Colorado Geological Survey comments for:
EP-24-0080 Crystal Park Site S-122 (AR) Site Plan
NW¼ NE¼ Section 18, T14S, R67W, 6th Meridian
38.8385, -104.9308

The referral documents included the Site Plan (LGA Studios, 9/5/2024), Geologic Hazard Study (Rocky Mountain Group (RMG), 5/17/2024), and Soils Report (A Better Soil Solution, 9/7/2023) for the proposed residence at 6881 Eagle Mountain Road.

ROOFING: BARNWOOD  
 STUCCO COLOR: CRYSTAL BROWN  
 GARAGE DOOR: PARK GREEN  
 STONE: OUTDOOR STONE BEGIE

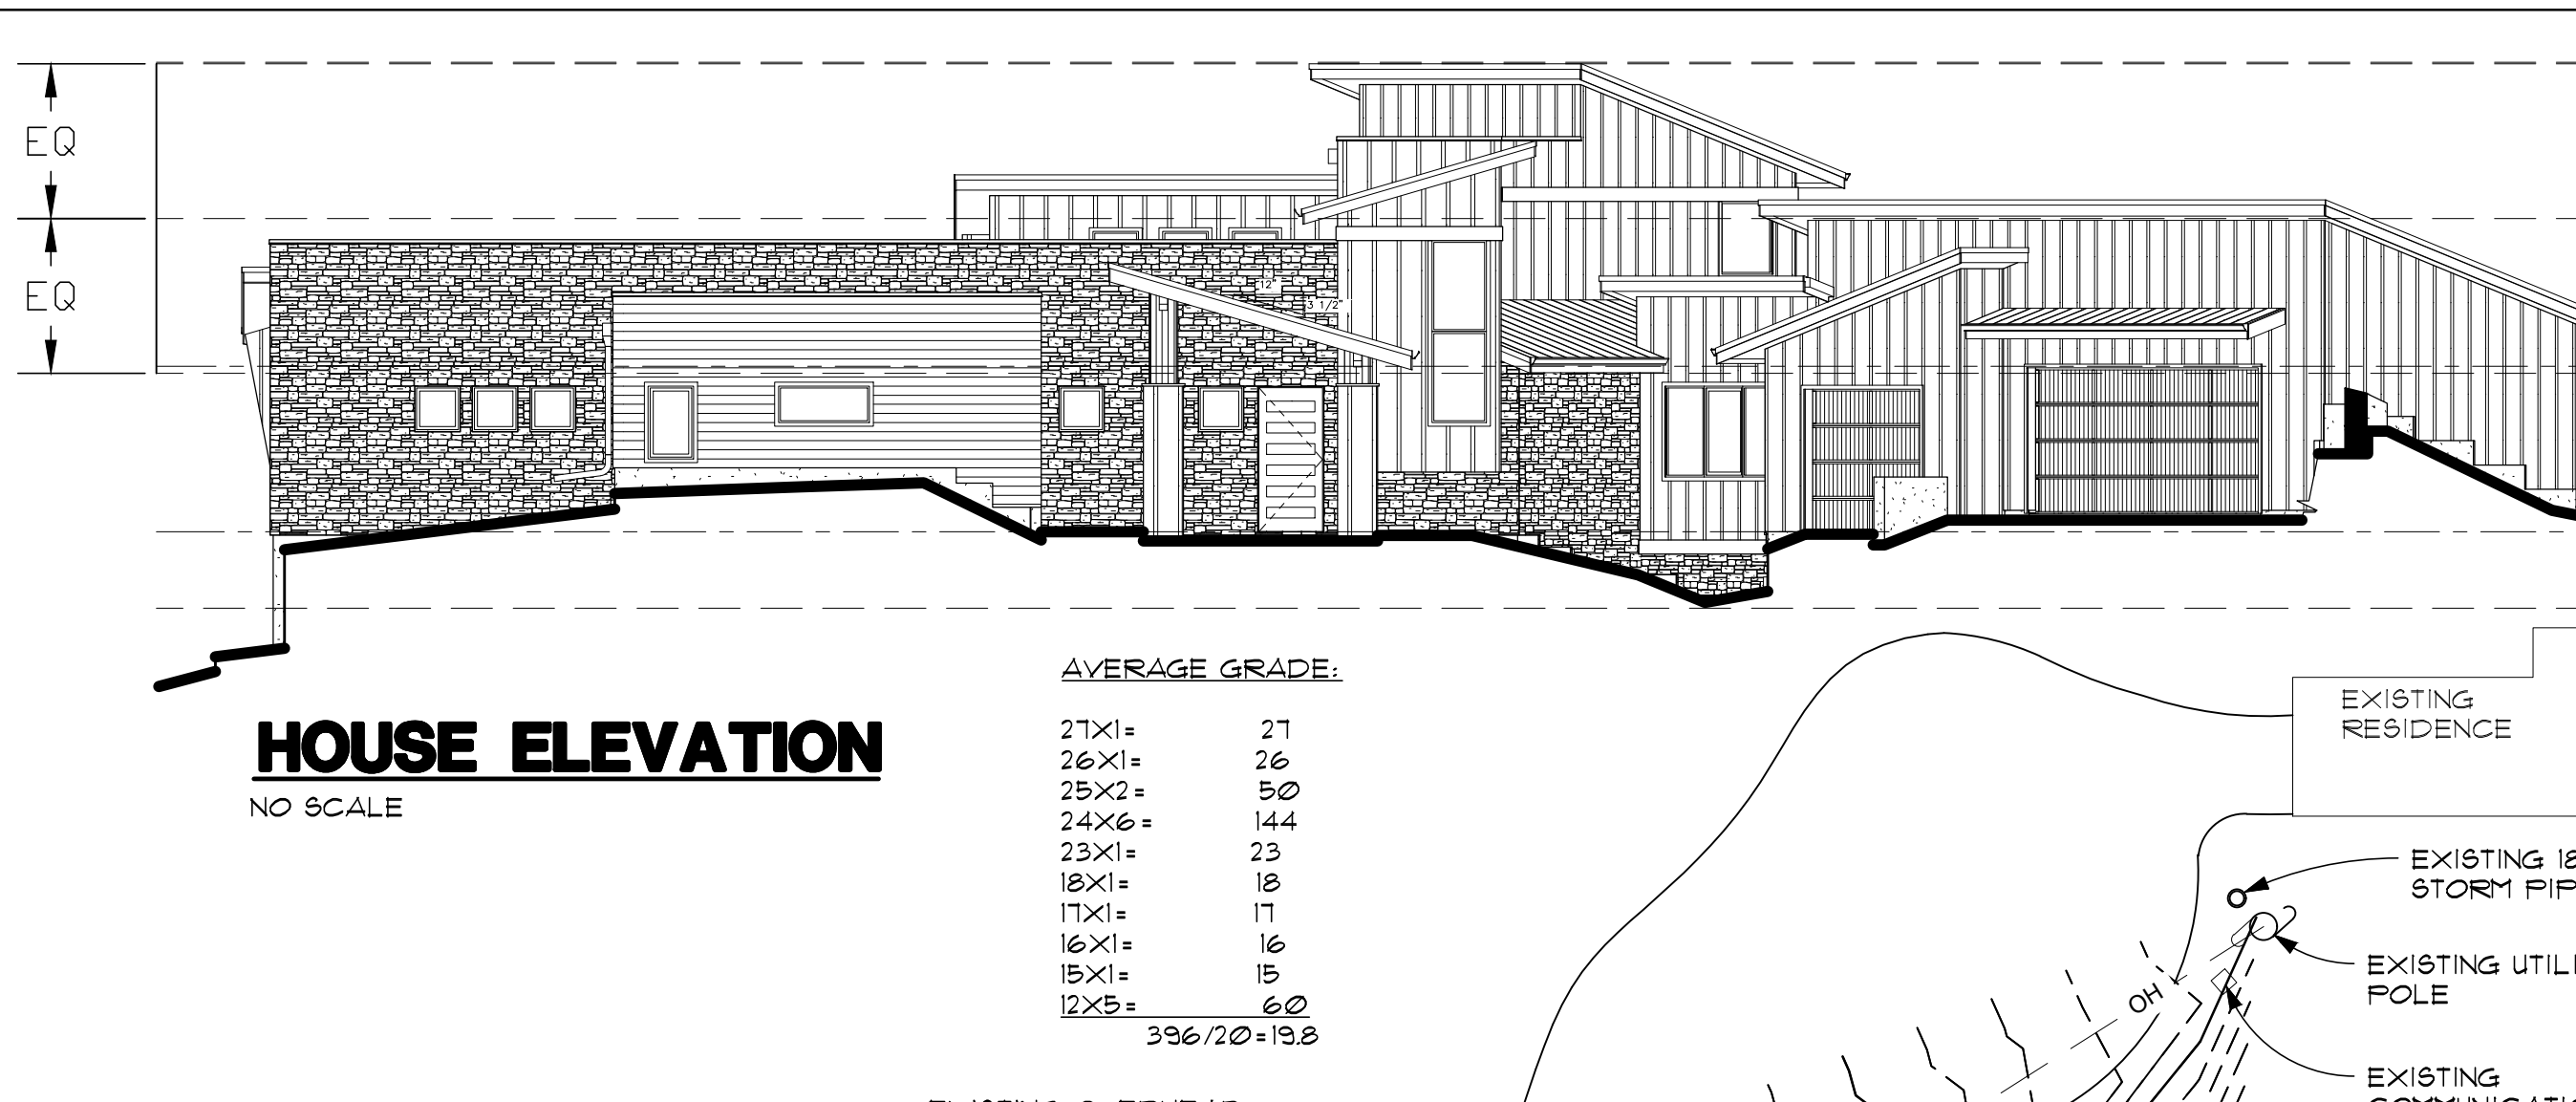
Site S-122 does not contain rockfall hazards or mapped landslides but does contain steep slopes, up to 60 to 70 percent descending south and east, and 1041 hazard mapping describes these slopes as potentially unstable to unstable. Based on the site plan showing existing grades, it appears that the proposed residential structure will be located within the flatter area of the site (about 5 to 10 percent).

3. CGS recommends that all planned cuts exceeding *four feet* in height be evaluated for slope stability using proposed slope geometry and considering all foundation and proposed cuts that will affect the slope. The geotechnical engineer should be provided with the construction plans and grading information to verify the proposed slopes.

5. The site plan indicates a leach field (septic location) is planned northeast of the proposed residence. Engineered septic systems are commonly used in the Crystal Park area due to the steep slopes and geology.
